Address: 27A, Wyke Lane, Bradford, BD127EE

Application number: 2025/93235	
What is the application for?:	Removal of the Cross and reinstatement within the grass verge on Cross Street/Wy
Address of the site or building:	The Cross, Wyke Lane/Cross Street, Oakenshaw
Postcode:	HD1 2NF

## Objection to planning of re-siting of Oakenshaw Cross. 2025/93235

Drawing Title General Arrangement and Detail Drawing

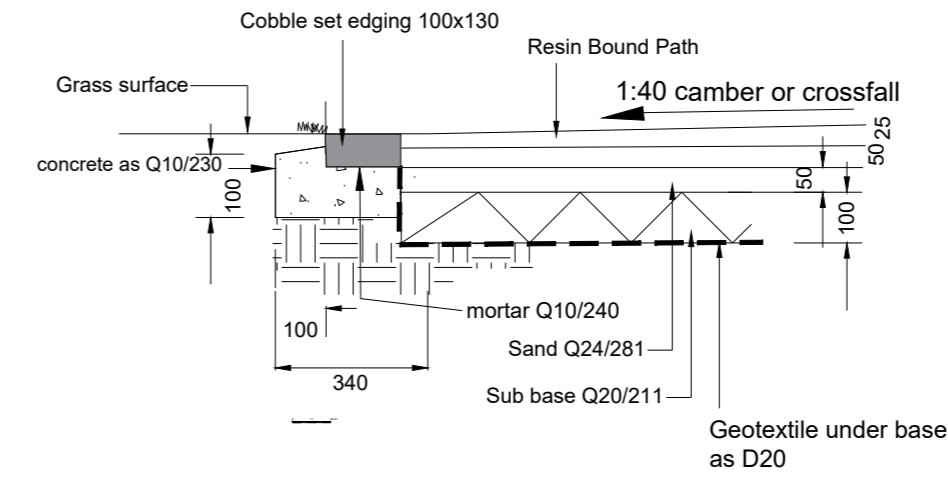
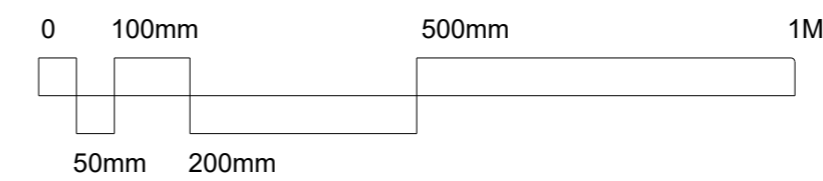
7. In the Design and Access statement the re siting of the Cross says it will be 12m away from its original site, but other documents refer to 15m and 20m? It must be clearly visible from Wyke lane when travelling East or the prominence as a visual marker of the village centre is lost.
